Your Ref: OWPC20738
Our Ref: EP/166/18/HH 13-11-2018
Please ask for:
Zac Denton

Erection of a two storey rear extension, second storey enlargement of side dormer and conversion of garage to study including demolition of existing conservatory
100 Sea Road East Preston

Thank you for your internet representation made on 28th November 2018 which has been recorded as '**an objection**' with the comments as follows:

Proposed Floor Plans, Elevations, Roof Plan and Block Plan

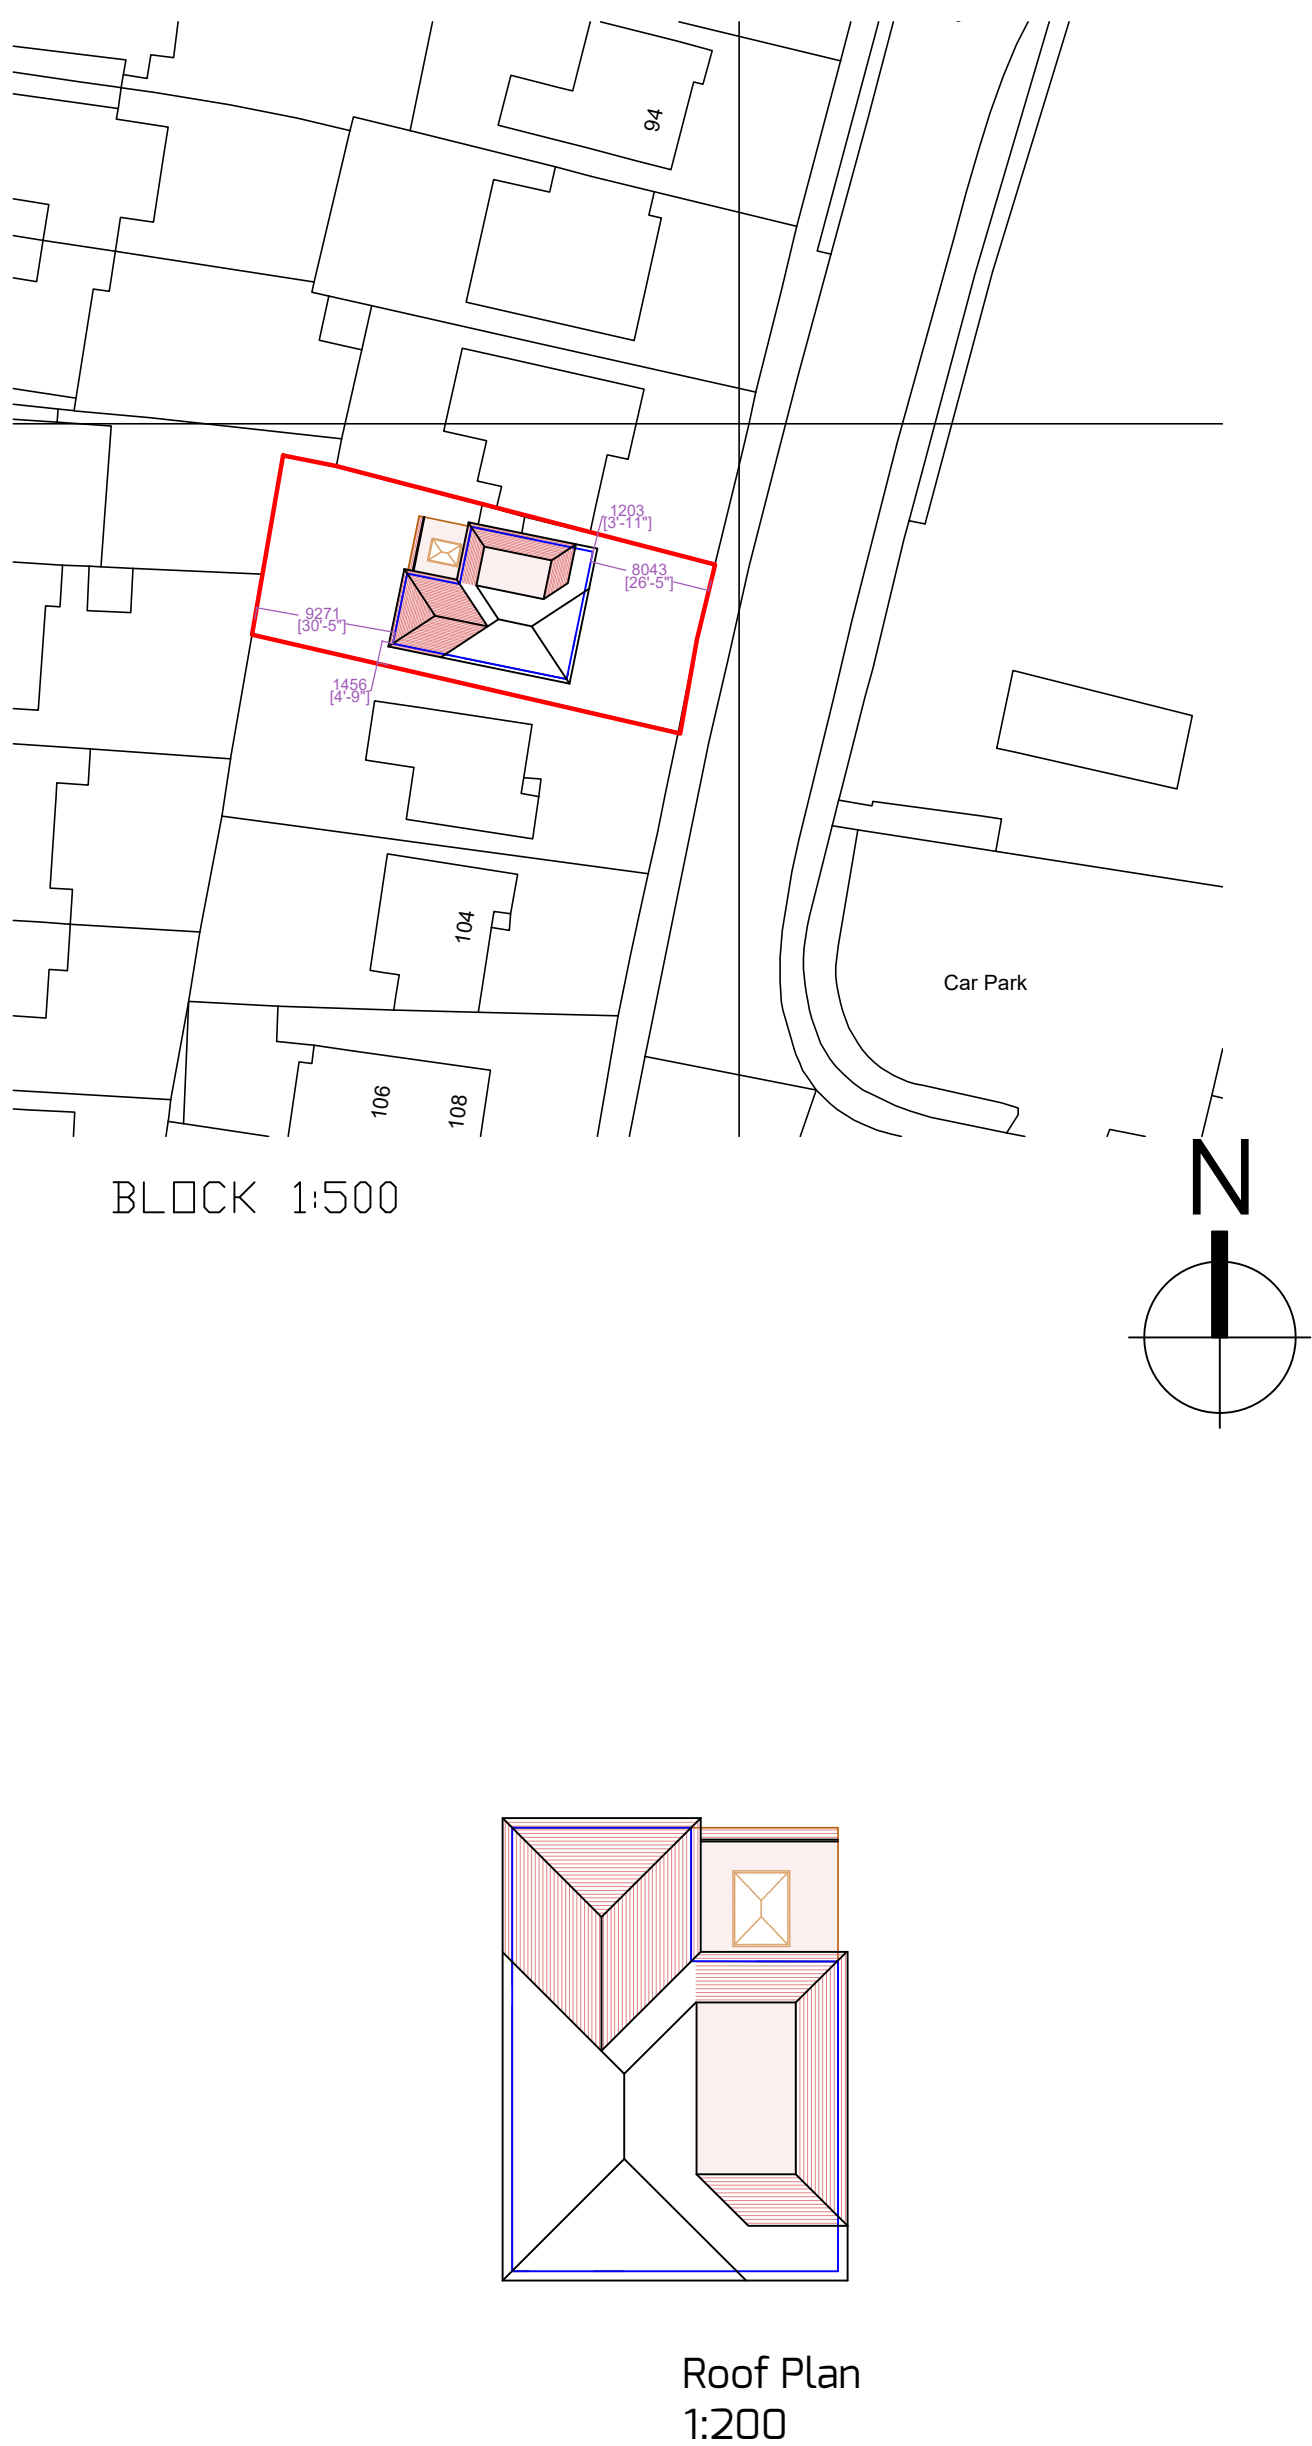
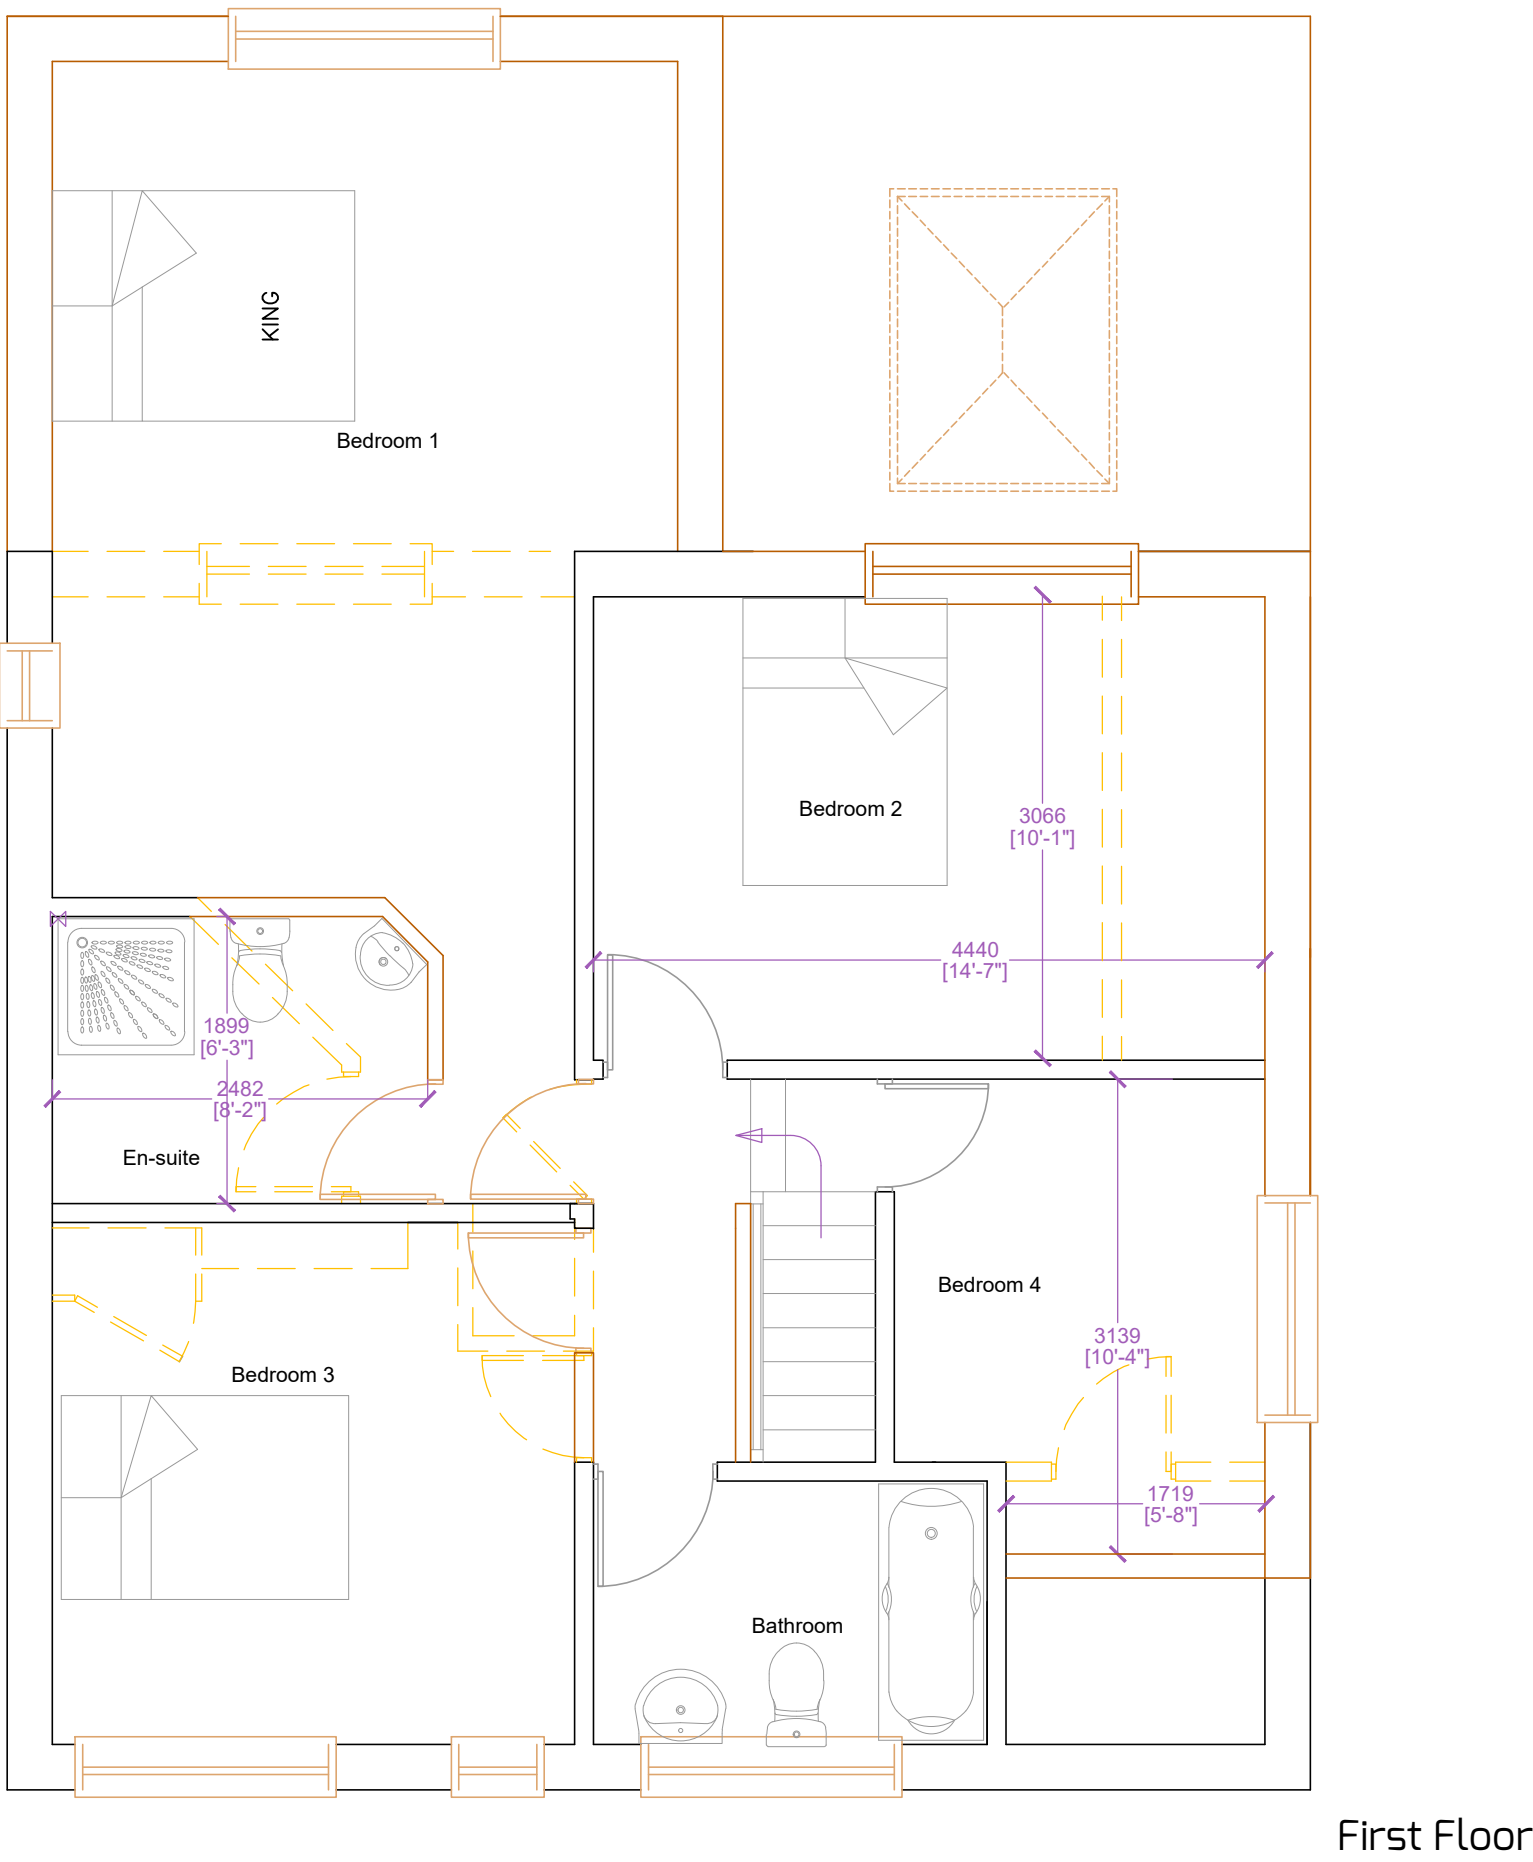
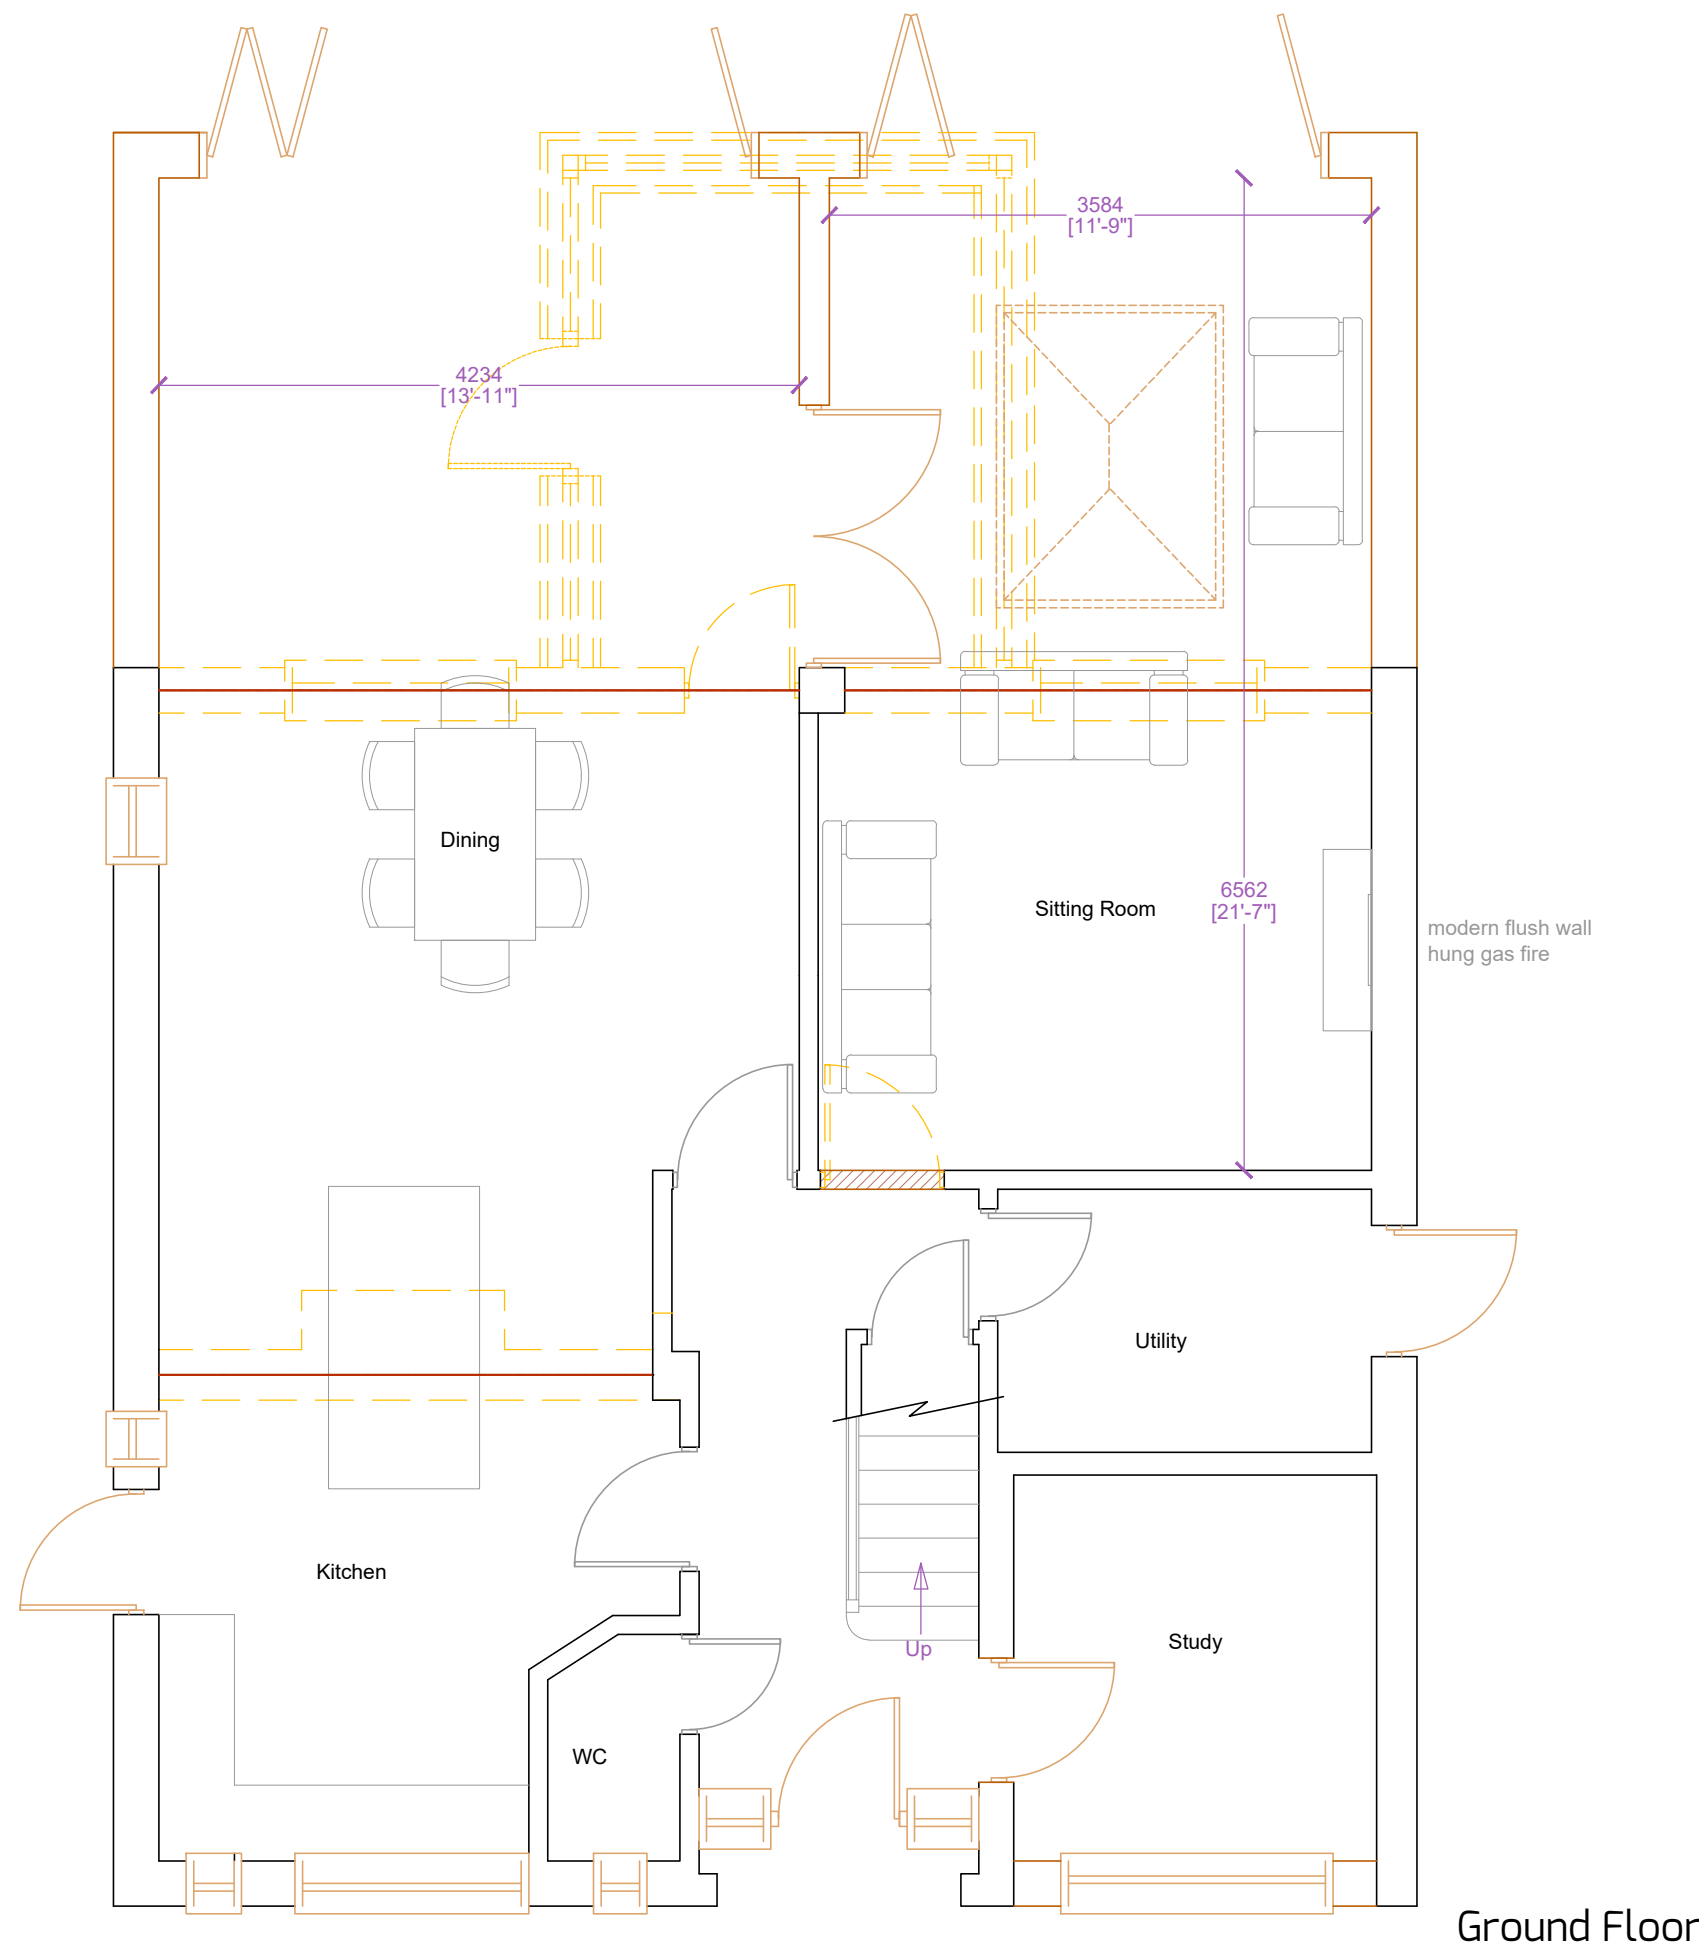
We feel that a double storey extension would be totally overbearing for the small gardens at this end of Sea Road which overlook the bungalows of Normandy Lane.

We use our conservatory as a dining room and our double doors open onto a patio area directly opposite what will be the huge new brick wall of the proposed extension which extends 3.5m beyond the current building line.

A single storey extension would have been fine but the proposed two storey is close to our boundary and also has a full height apex roof. It will totally overshadow and enclose our small patio area and restrict the light, particularly to our small utility room.

We were not aware of our neighbour's plans until after planning permission had been submitted but we are sure that the plans could be revised to create the extra living space needed without the enlargement of bedroom one and we hope a compromise will be considered to avoid this double storey section.

We feel the current proposal would make this house out of scale with other houses in Sea Road. The garden is too small for this size of extension which will be overpowering in ground space but more concerning is the height impact that both the second storey enlargement of the side dormer and a two storey extension will create.

It is not just about loss of privacy and light but the visual impact from all sides and when looking directly from Normandy Lane the road behind us. At this end of Sea Road the houses are close together with particularly small gardens backing onto bungalows and if this is allowed to happen it will set a precedent for other two storey extensions in Sea Road which will only see the area becoming even more built up.
